DRB CASE ACTION LOG (SITE PLAN B.P.)

DRB Application No.: 04DRB-01012 (SBP)

Project # 1003524

Project Name: LANDS OF SPRINGER MATER.

SHEET NUMBER
A-2

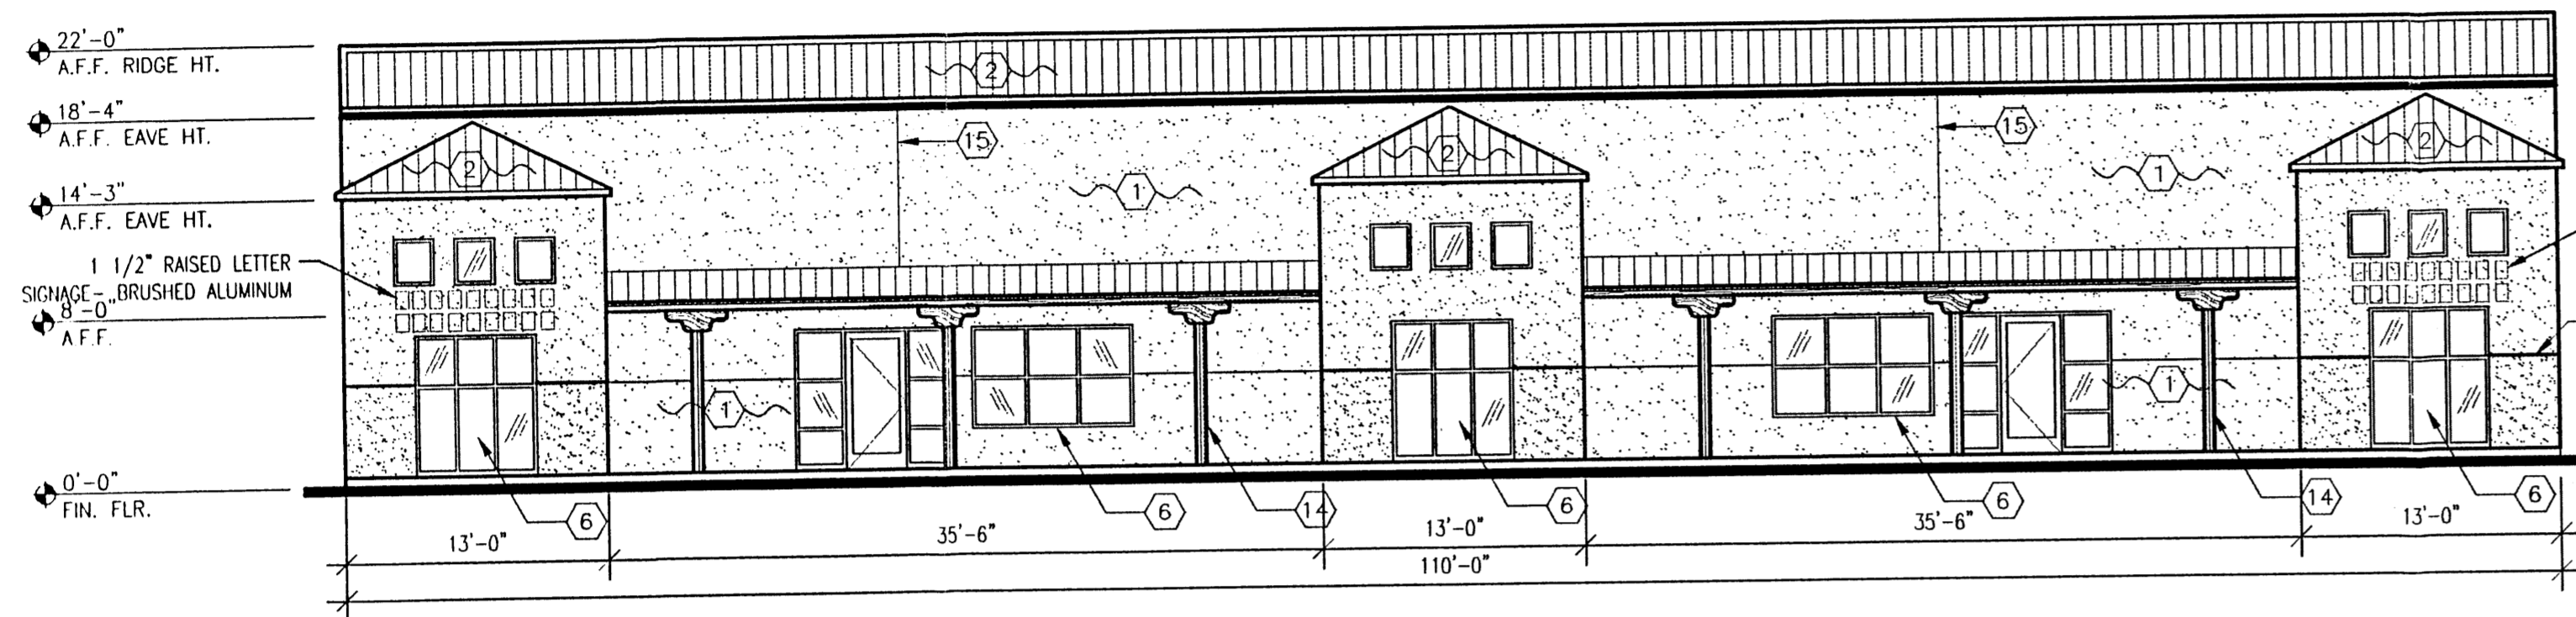
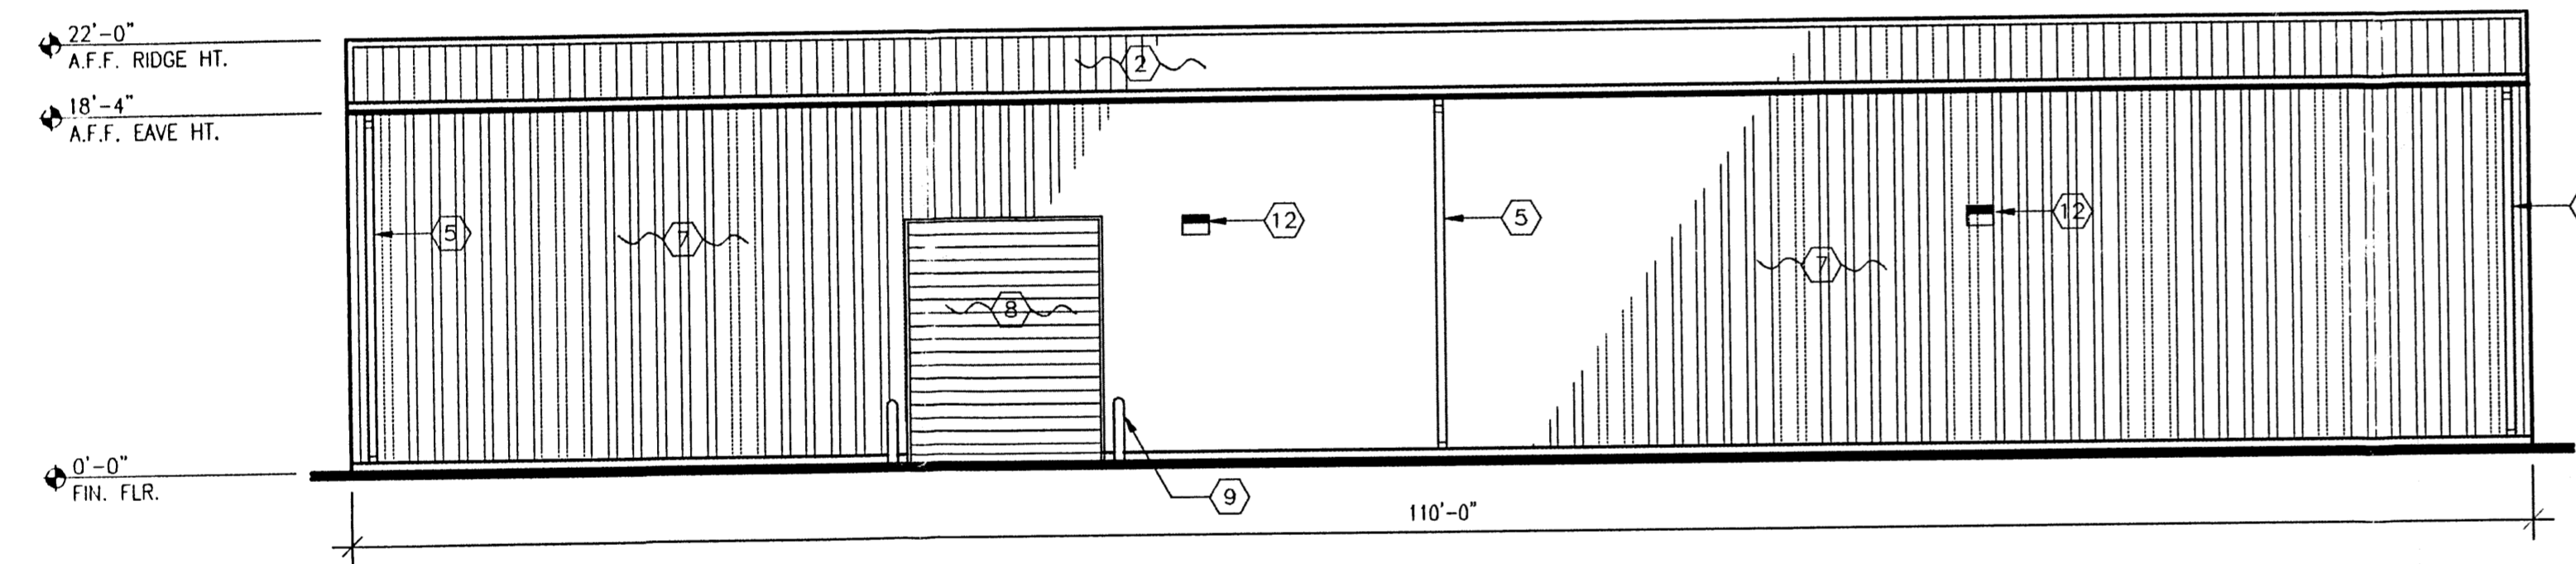
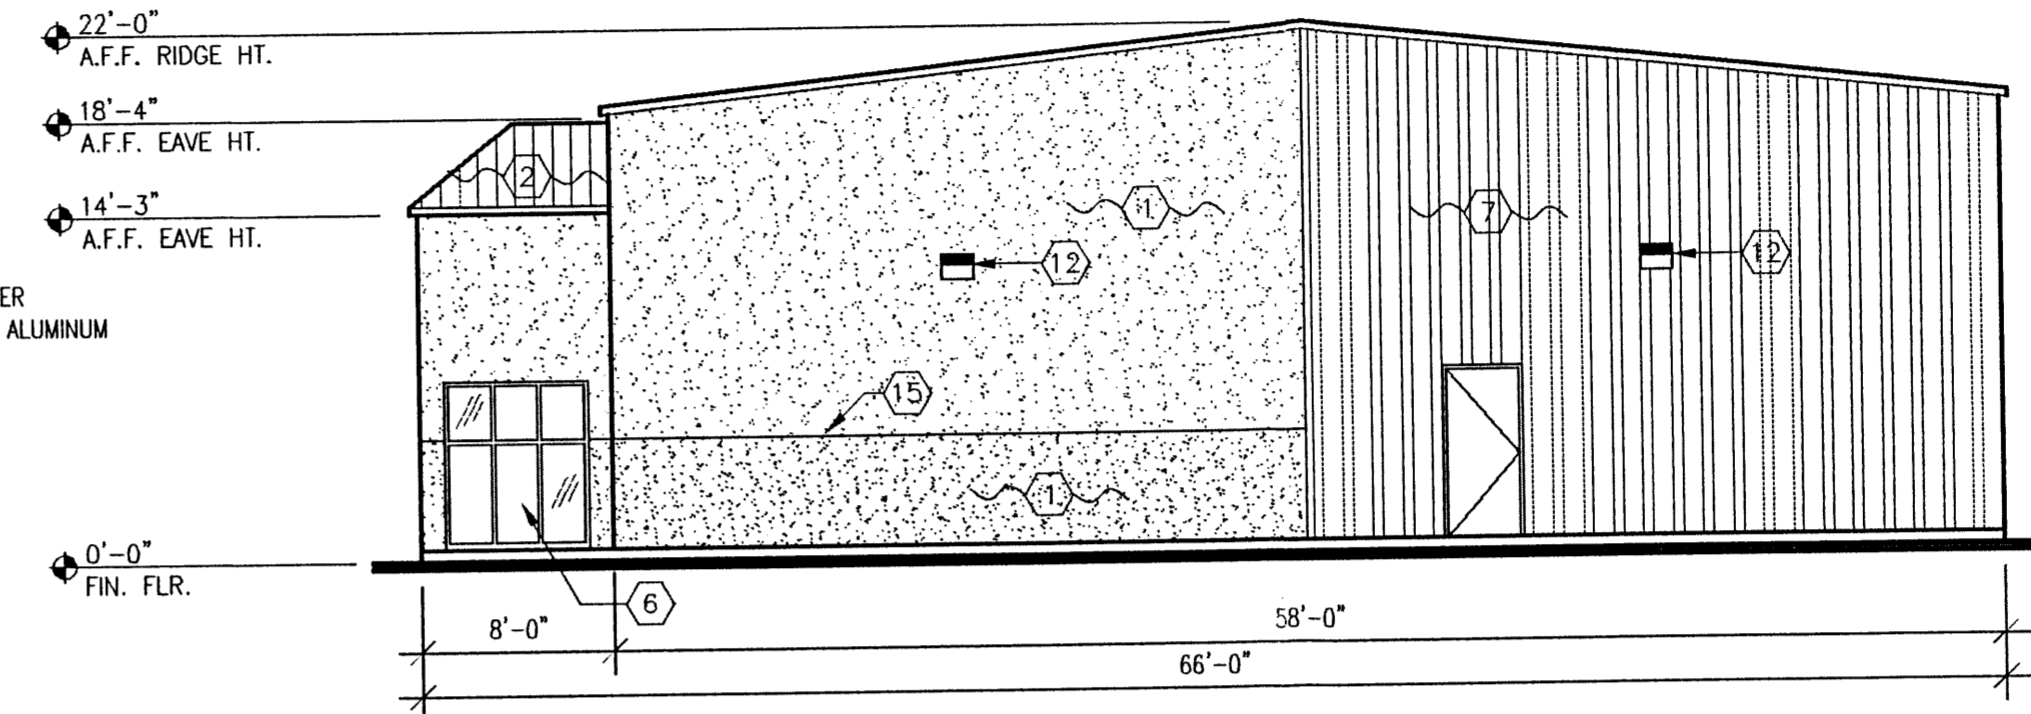
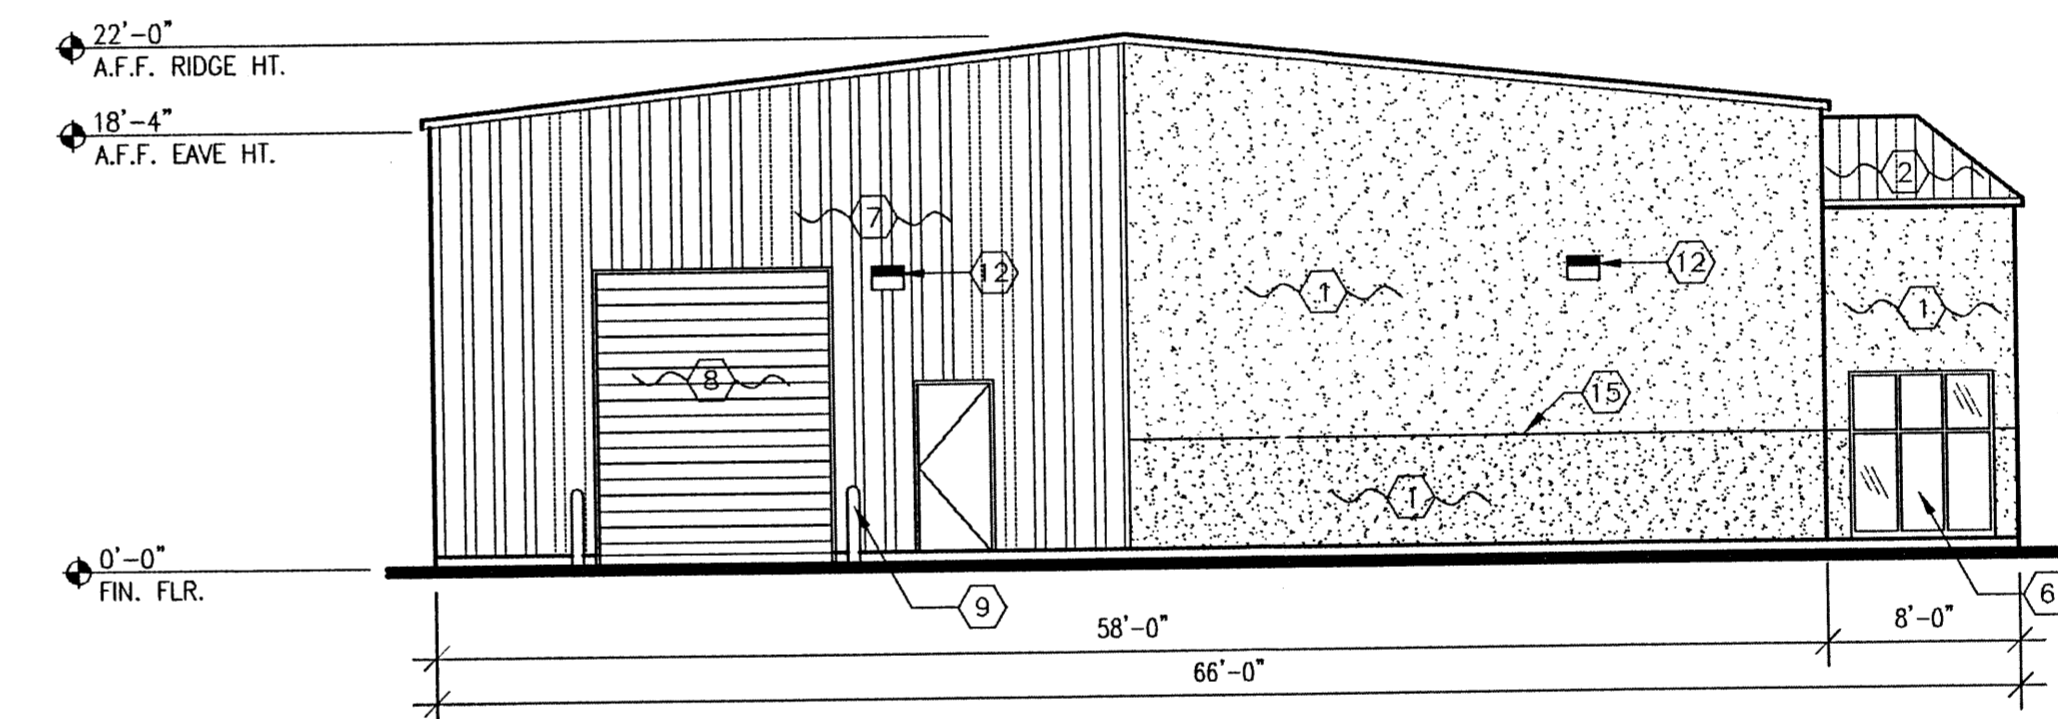
- PLANNING (Last to sign): Sign on Bldg ~~ACTD signature~~
- of [Signature]
- _____
- _____

9. **Project # 1003524**
04DRB-01012 Minor-SiteDev-Plan
BldPermit
- RICK BENNETT ARCHITECTS agent(s) for WASHINGTON STREET INVESTMENTS request(s) the above action(s) for all or a portion of Lot(s) 17, Tract(s) B-1-A-1, ALAMEDA BUSINESS PARK, **LANDS OF SPRINGER BUILDING MATERIALS CORP.**, zoned SU-2, IP - EP, located on VISTA ALAMEDA NW, between PASEO ALAMEDA NW and ALAMEDA PARK DR NW containing approximately 1 acre(s). *[Deferred from 7/14/04]* (C-16) **SITE PLAN FOR BUILDING PERMIT WAS APPROVED WITH FINAL SIGN OFF DELEGATED TO TRANSPORTATION DEVELOPMENT FOR ONE- WAY SIGN, CITY STANDARD DRAWING NUMBER FOR CURB CUTS AND PARALLEL INTERIOR PARKING STALLS 22 FEET AND PLANNING FOR SIGNAGE ON BUILDING.**
